SOLACE AT CIMARRON HILLS

SITUATED IN THE NORTHWEST QUARTER OF SECTION 7
TOWNSHIP 14 SOUTH, RANGE 65 WEST OF THE SIXTH PRINCIPAL MERIDIAN
COUNTY OF EL PASO, STATE OF COLORADO
SANITARY SEWER PLAN AND PROFILE

SOLACE AT CIMARRON HILLS
SANITARY SEWER PLAN AND PROFILE

WATER DISTRIBUTION PLAN

**SP01 PROFILE (2)  
 STA 9+00.00 TO 17+80.00**

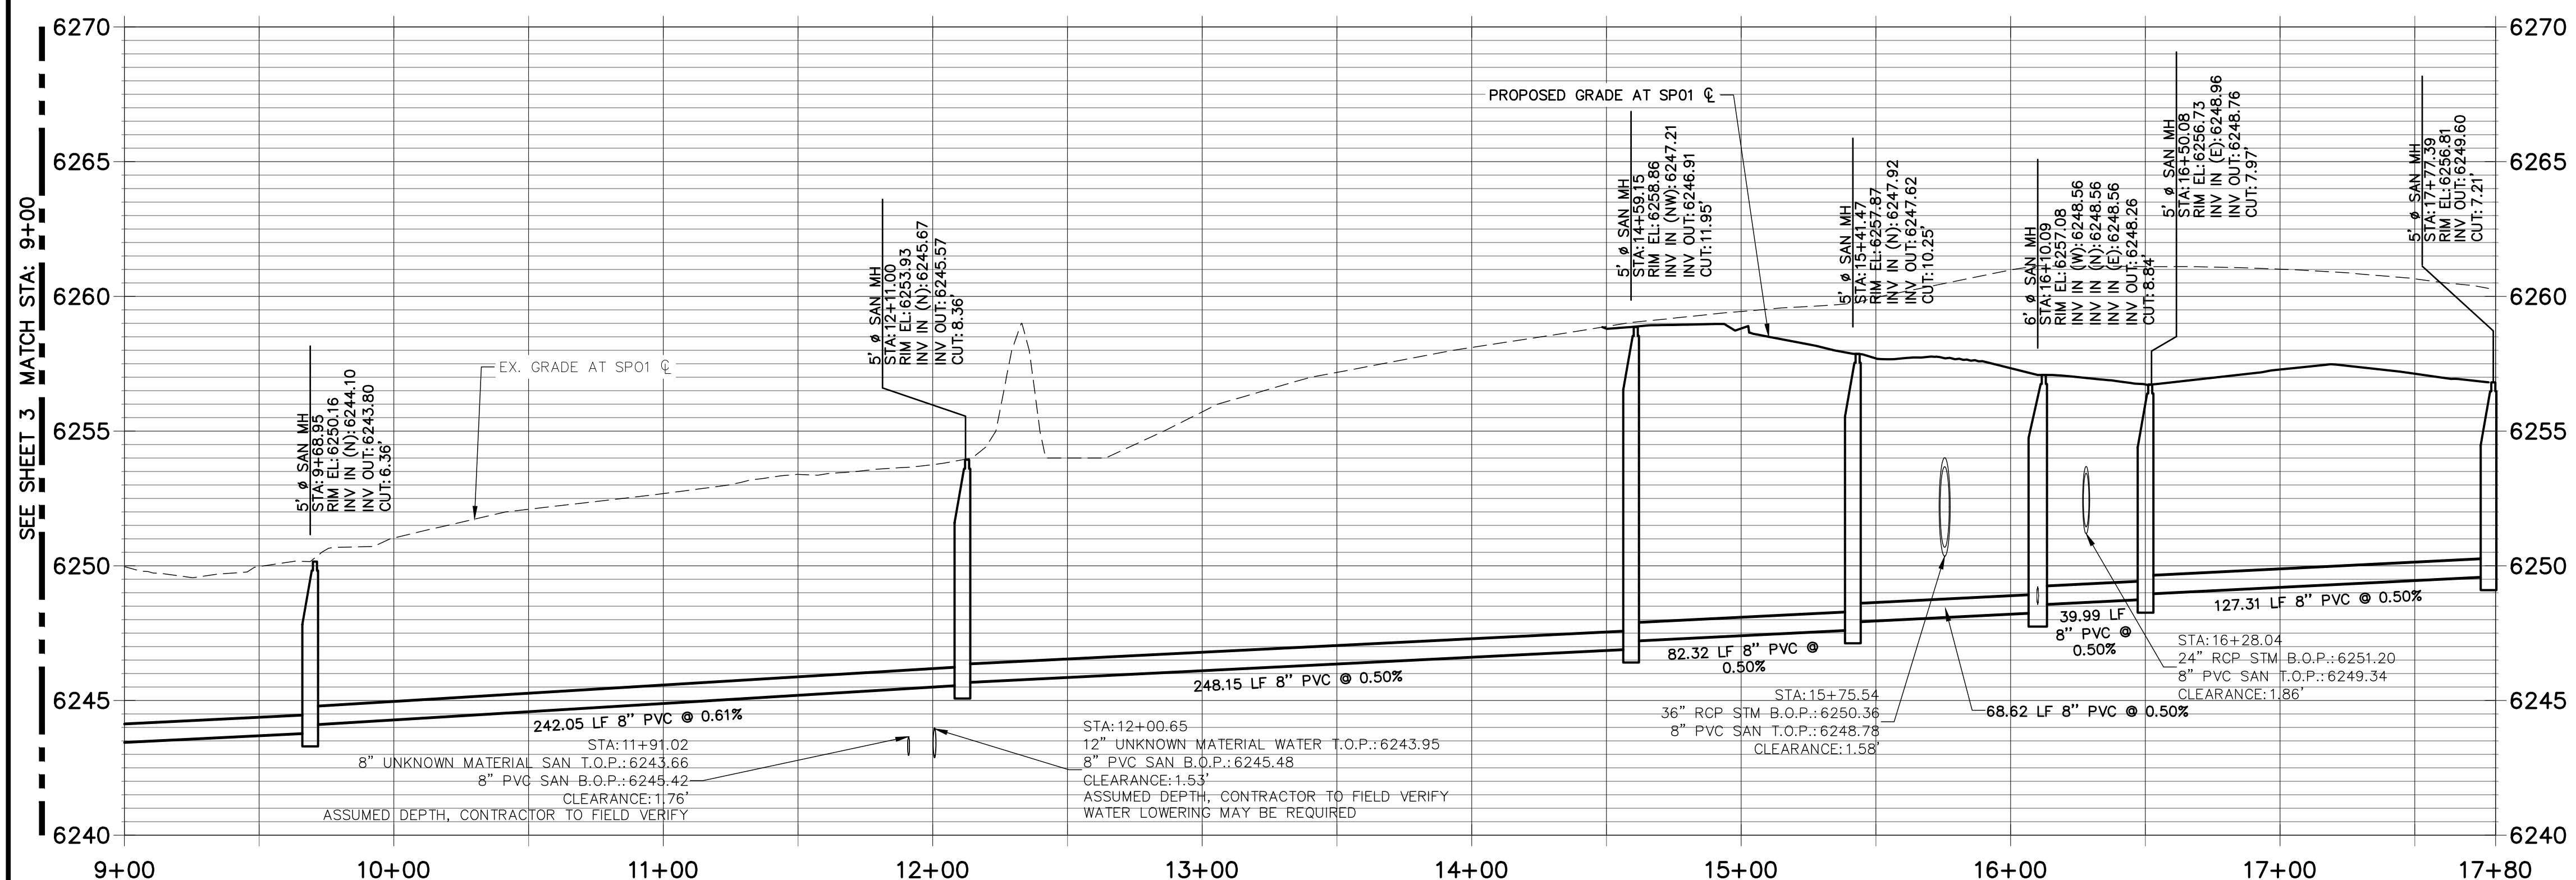
ADD NOTES 182 FROM SHEET 4 & 5 OF 28 SITE DEV. PLAN SET FOR PUBLIC SANITARY SEWER SYSTEM TYP ALL SHEETS

LABEL SERVICE LINES & PROVIDE CLEAN OUT ON SERVICE LINE SEE CS4 STD D1-4 TYP ALL PLAN & PROFILE SHEETS

PROVIDE MATERIAL & SIZE

**WL-8 PROFILE  
 STA 0+00.00 TO 6+65.00**

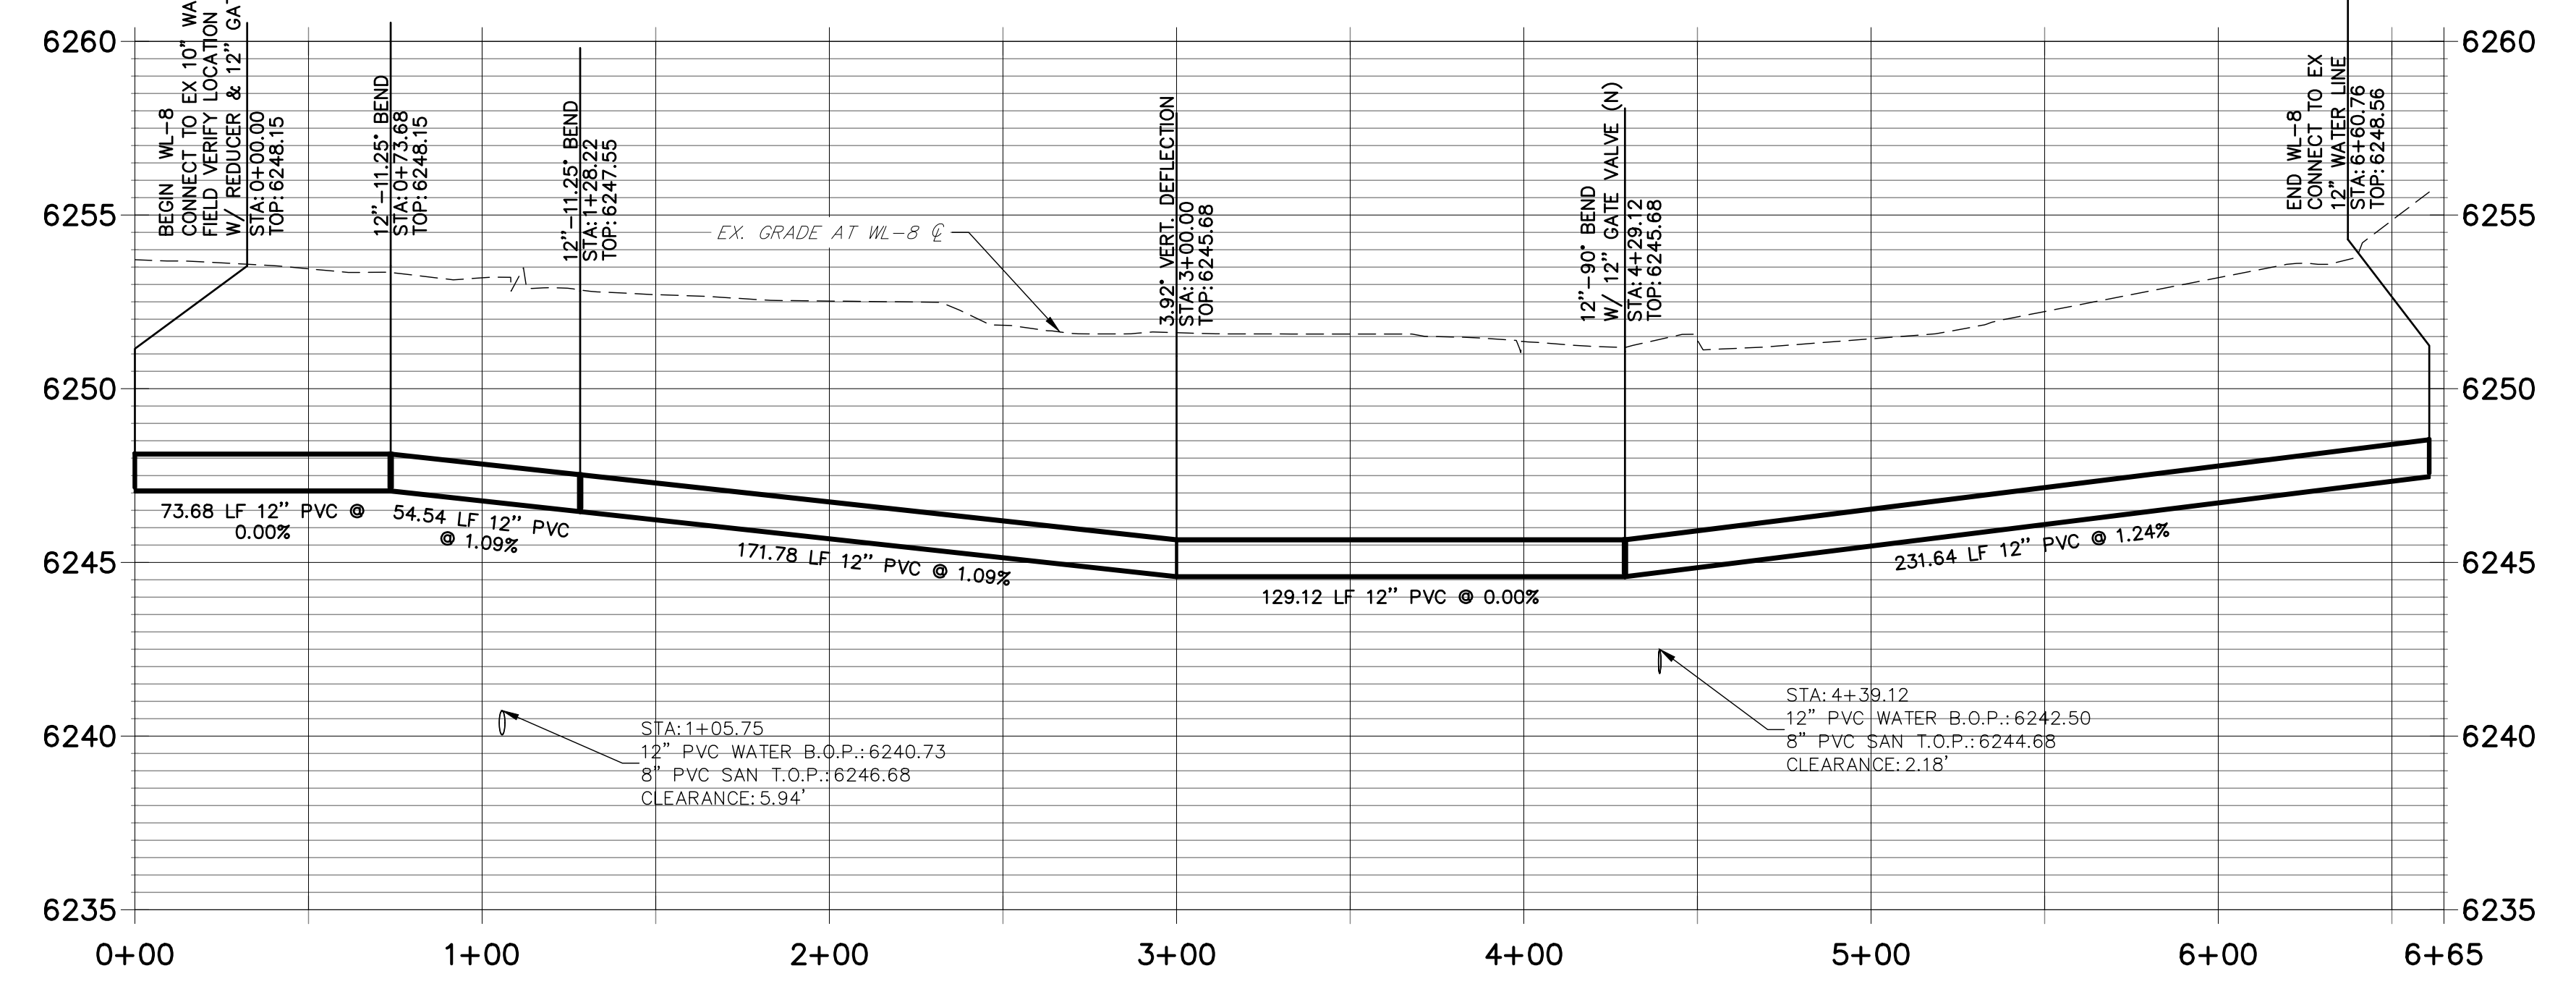
*MODIFY TO MATCH SHEET 5 OF 28
"SITE DEVELOPMENT PLAN"*

*REPLACE CMD STD REFERENCES
W/ CSU STDS. TYP ALL SHEETS*

*ADD NOTES ON SITE DEVELOPMENT PLAN SHEETS 4 & 5 OF 28 (NOTES 1 & 2)
TYP ALL SHEETS*

SOLACE AT CIMARRON HILLS	BY	DATE							
	No.	REVISION							
WATER DISTRIBUTION PLAN	H-SCALE	1"=40'							
	V-SCALE	1"=4'							
	DATE	3/12/21							
	DESIGNED BY	APL							
	DRAWN BY	APL							
	CHECKED BY								
SHEET	3	OF	10						
JOB NO.	25174.00

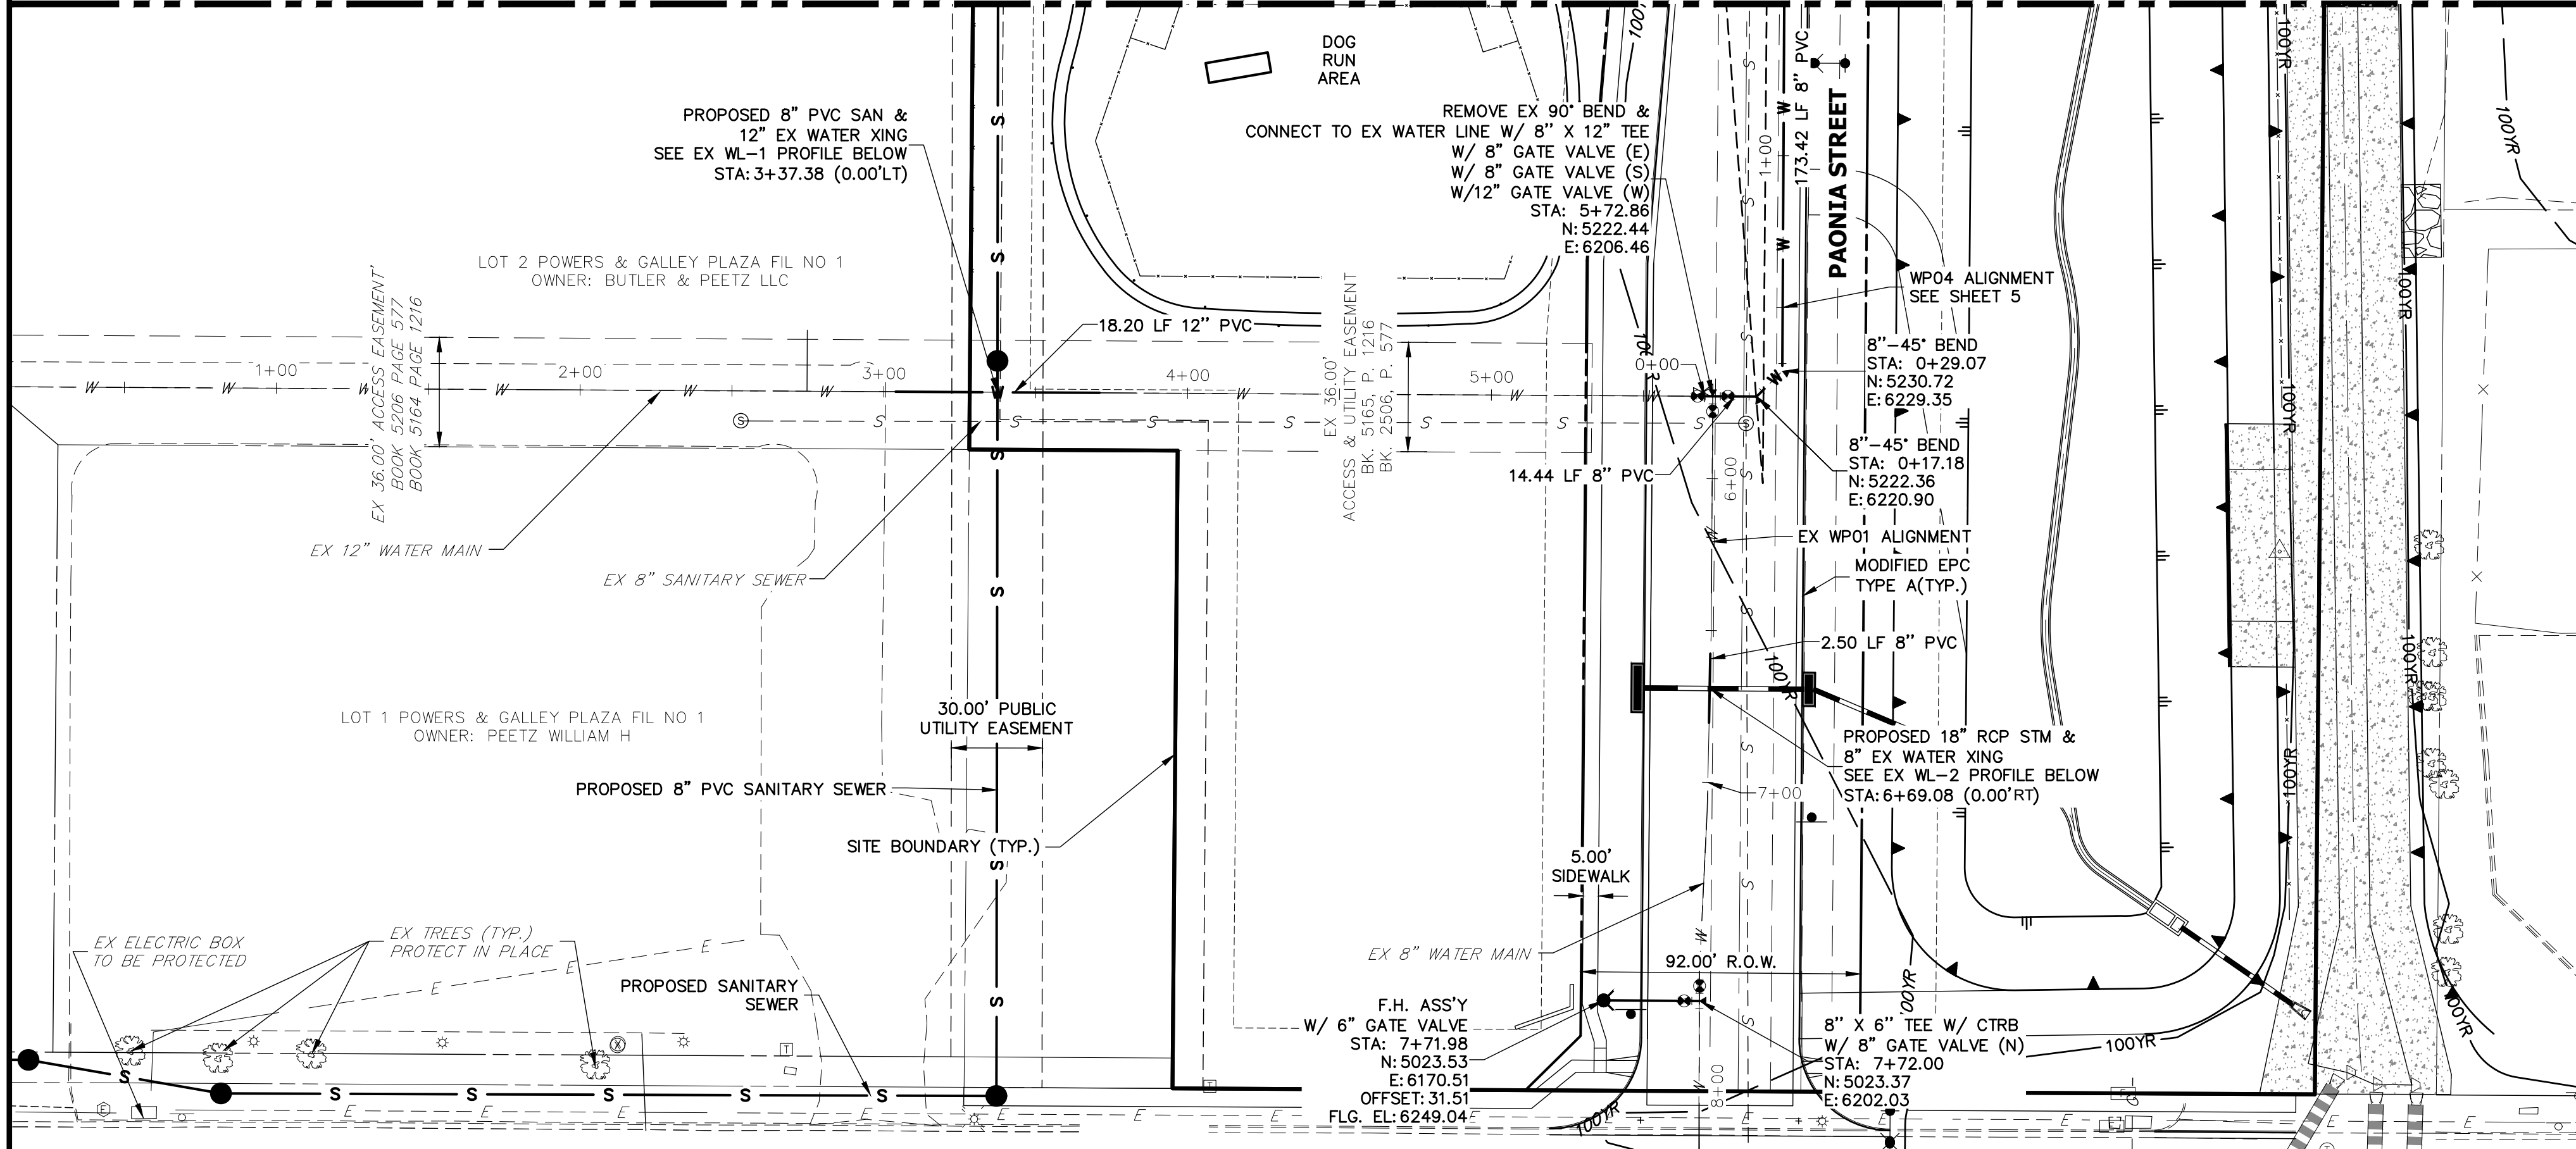
LABEL SERVICE & FIRE LINES SIZE & MATERIAL & SHUT OFF VALVES. SERVICE LINE TO BE HDPE BLUE. TYP ALL SHEETS

ADD VALVE TO MATCH SHEET 4 OF 28 "SITE DEV. PLAN"

REPLACE CMD REF STD'S W/ CS & STD'S.

BY	DATE	
	REVISION	
H-SCALE	1"=40'	
V-SCALE	1"=4'	
DATE	3/12/21	
DESIGNED BY	APL	
DRAWN BY	APL	
CHECKED BY		
<b>SOLACE AT CIMARRON HILLS</b>		
<b>WATER DISTRIBUTION PLAN</b>		
SHEET	4	OF 10
JOB NO.	25174.00

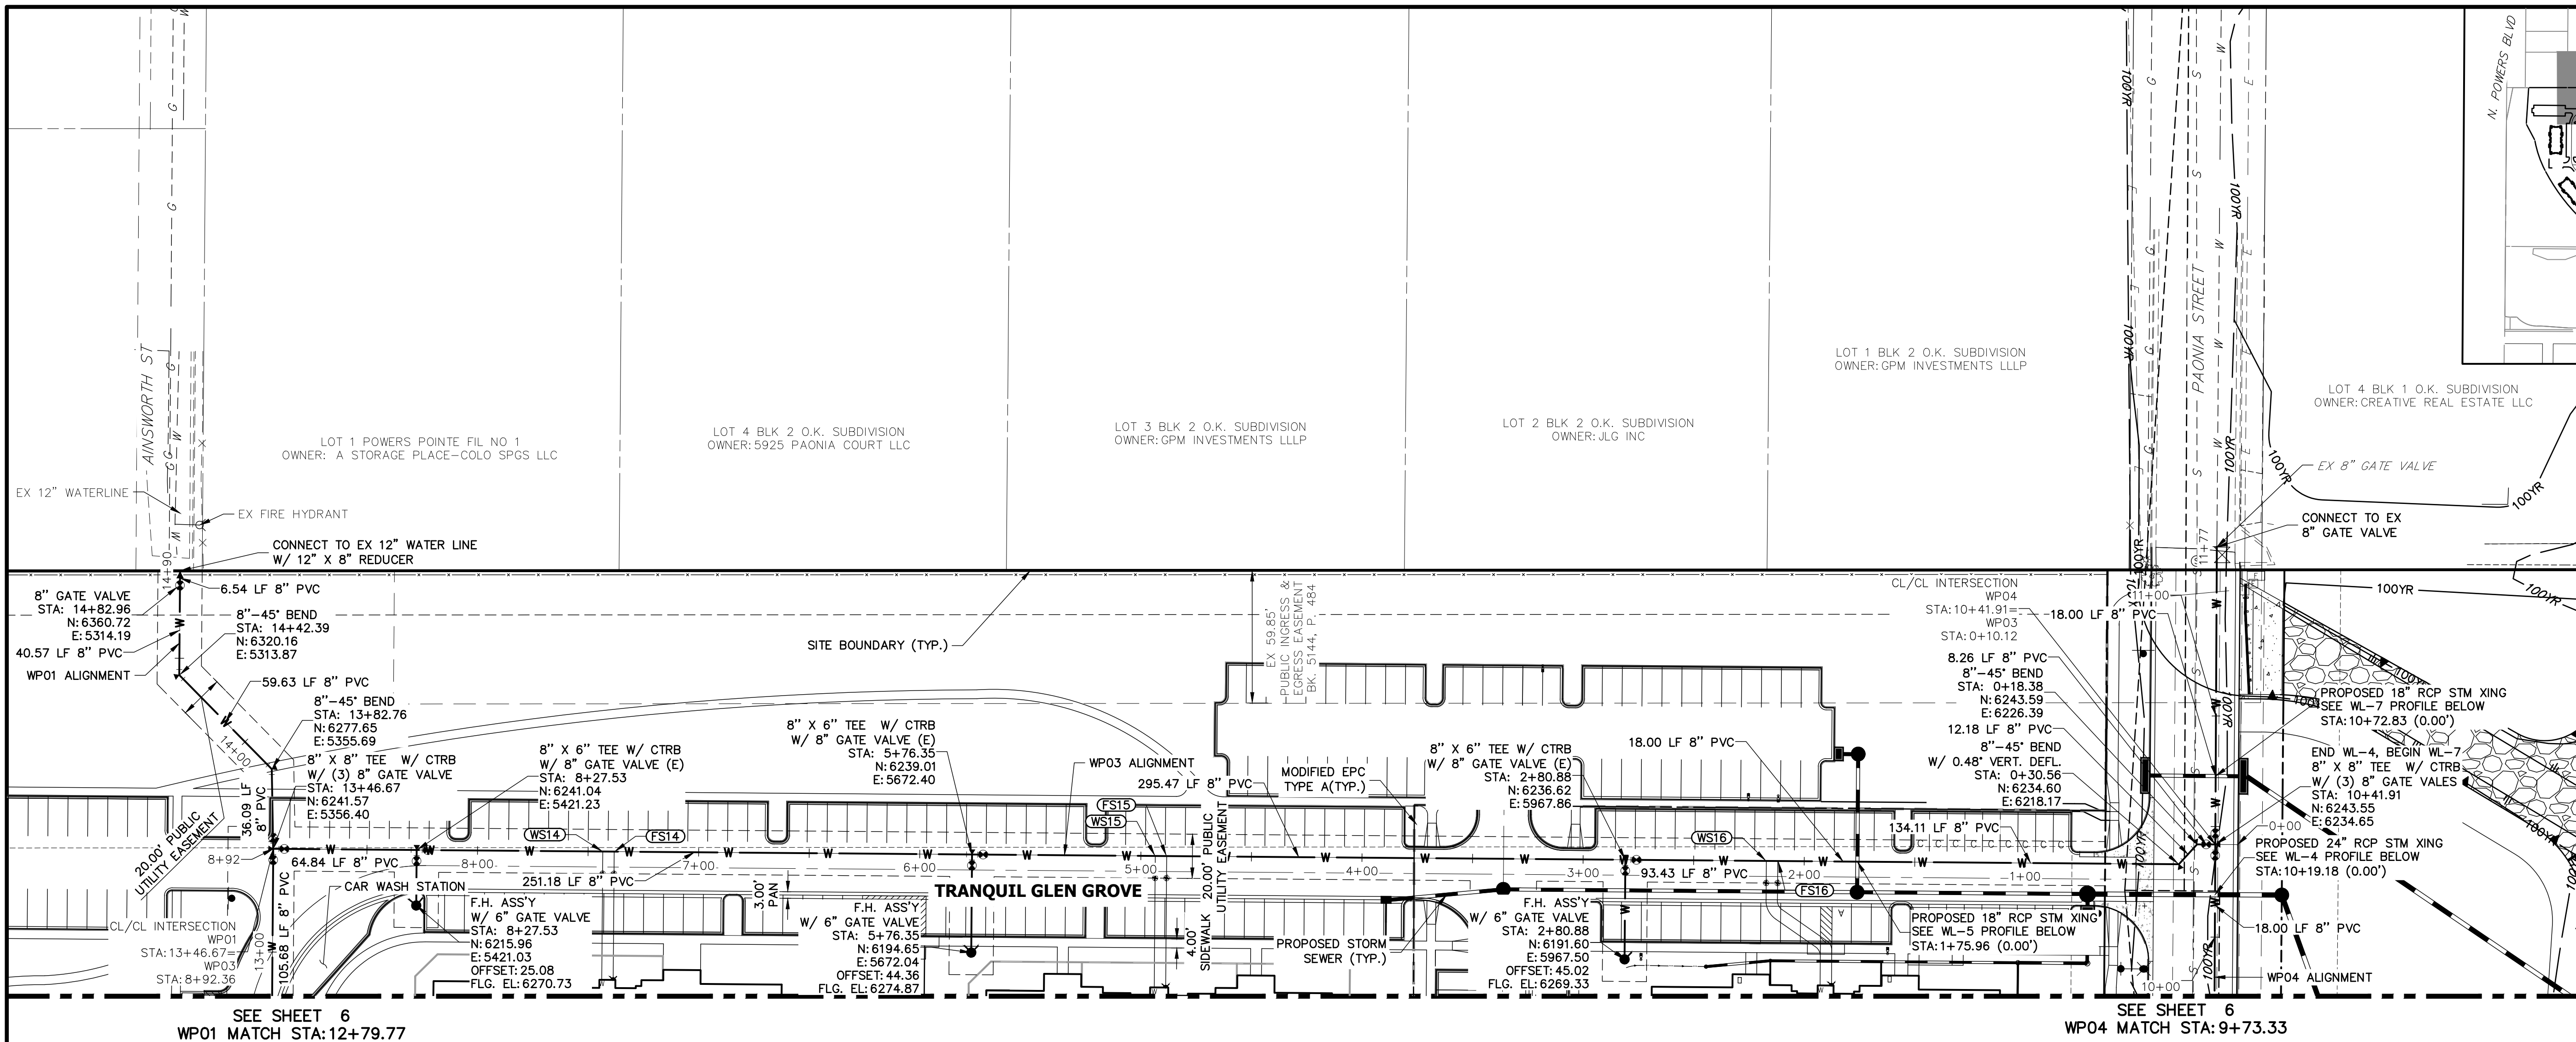
ADD SIZE & MATERIAL OR USE GENERAL NOTE

CONFIRM W/ FIRE DEPT THAT HYDRANT CAN BE BEHIND PARKING SPACE (TYP) WL-3 PROFILE

SHOW VALVES ADDED TO MATCH SHEET 4 OF 28 "SITE DEV. PLAN"

LABEL 30' PUBLIC UTILITY EASEMENT "NO COVERED PARKING FOUNDATIONS ALLOWED IN EASEMENT"
